March 19, 2020

El Paso County Development Services Department
Attn: Jeff Rice / Steve Kuehster, PCD-Engineering
2880 International Circle
Colorado Springs, CO 80910

**SUBJECT: Comment Response Letter (SF-19-014)
Bent Grass Residential Filing No. 2 Fourth Submittal**

# FINAL PLAT

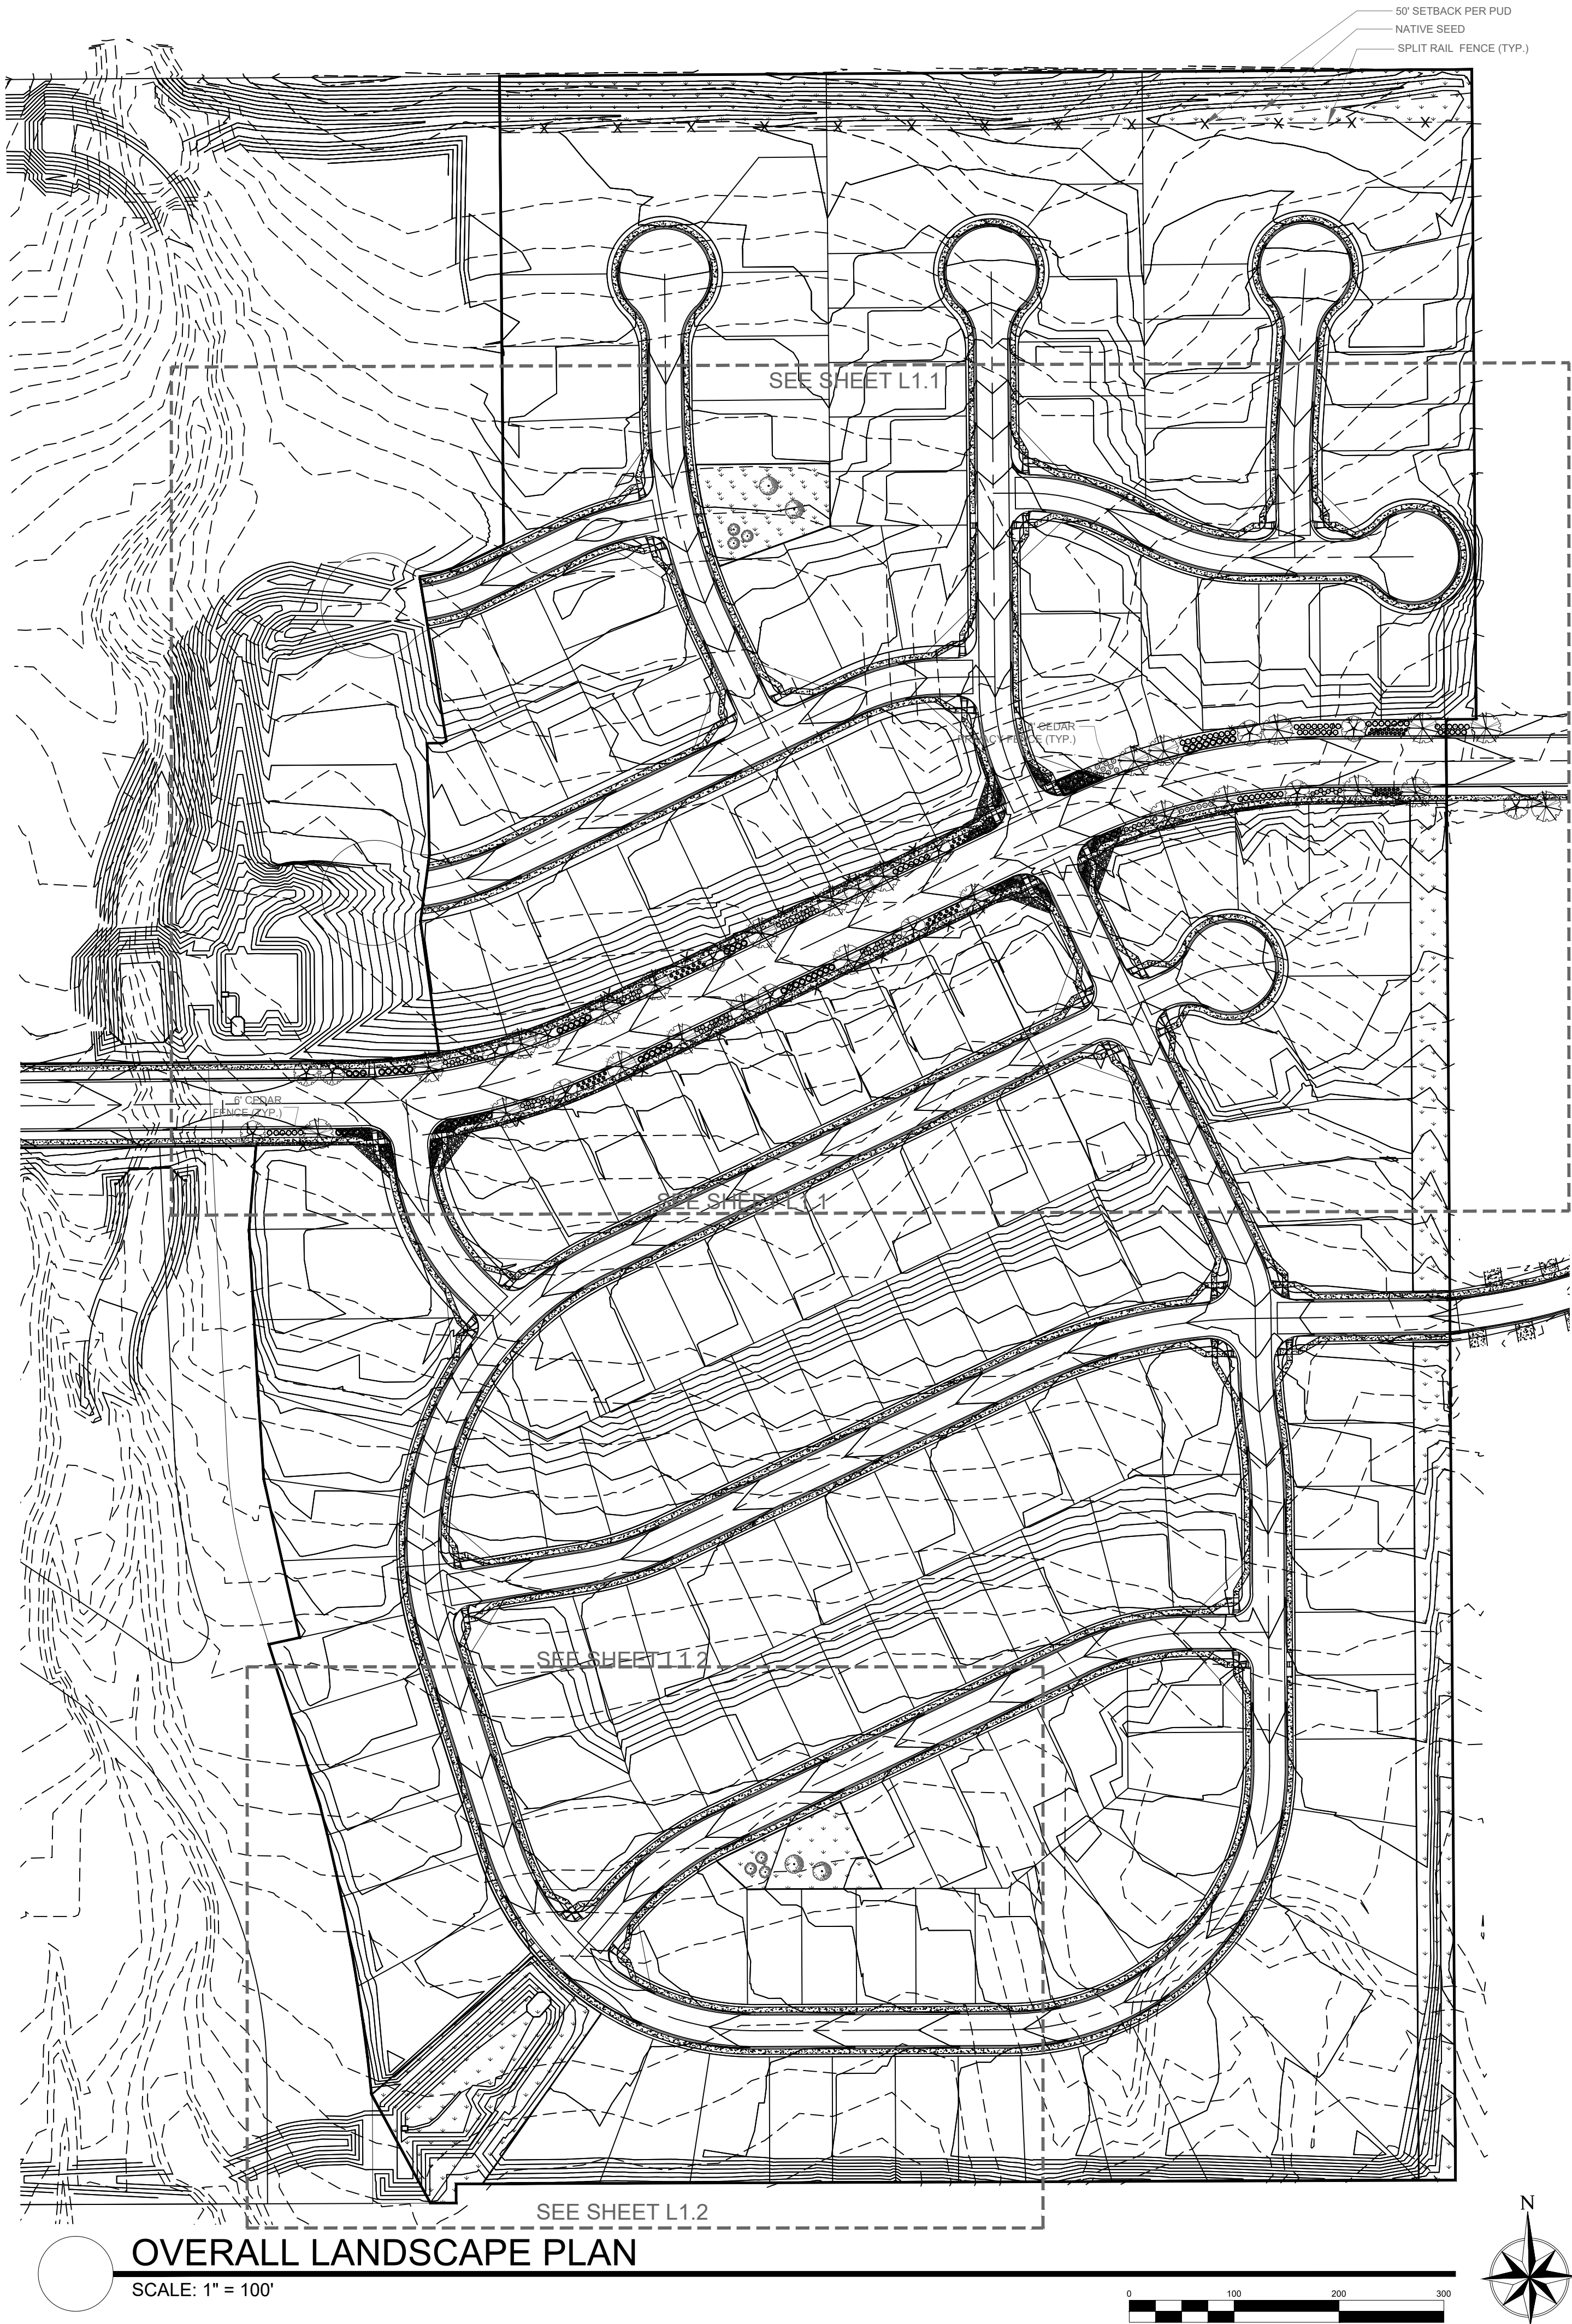
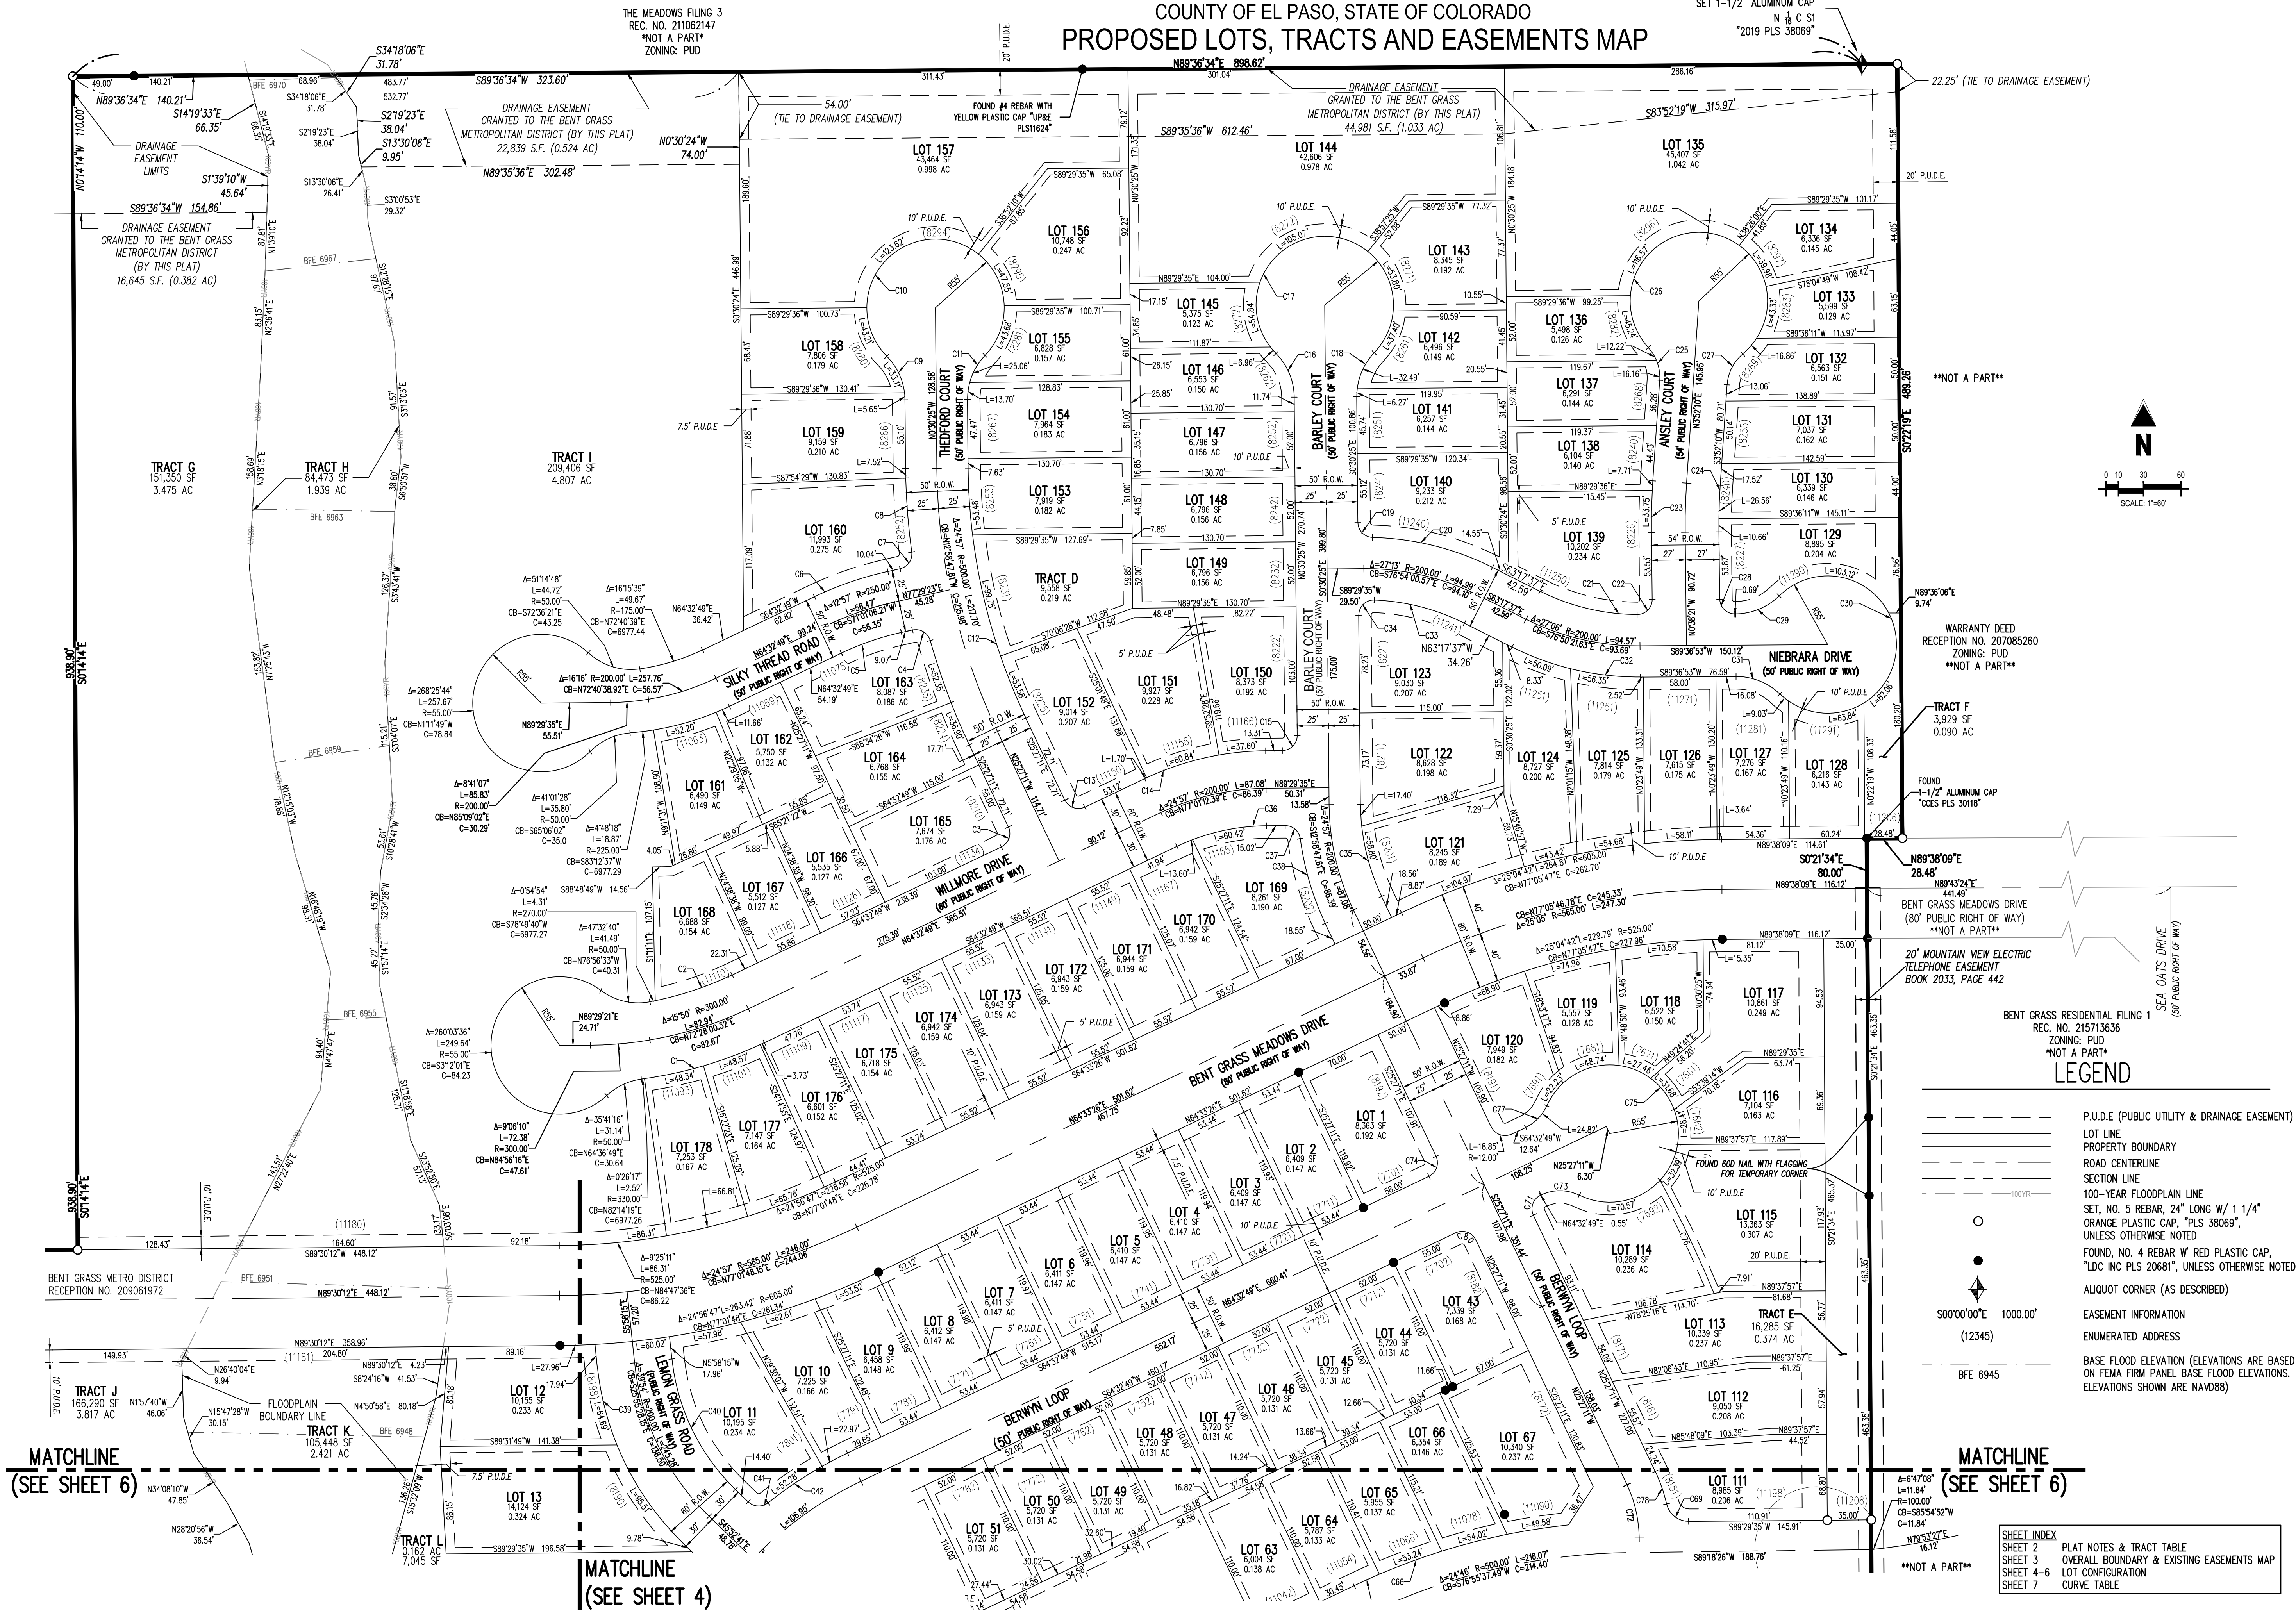
2. **Resolved.**
3. Resolved.
4. Regarding the necessary (redlined) temporary cul-de-sac easements (if not proposed as ROW), the template of the Non-Exclusive Permanent Easement can be provided electronically upon request. Unresolved. **Unresolved. Delete “temporary” from cul-de-sac labels. Provide NEPE form or show the cul-de-sacs with right-of-way which can be vacated and replatted when the roads are extended.**

Response: Removed “temporary” from labels. We are platting as R.O.W. instead of providing NEPE form. We will vacate and replat the extended roads when future filings begin.
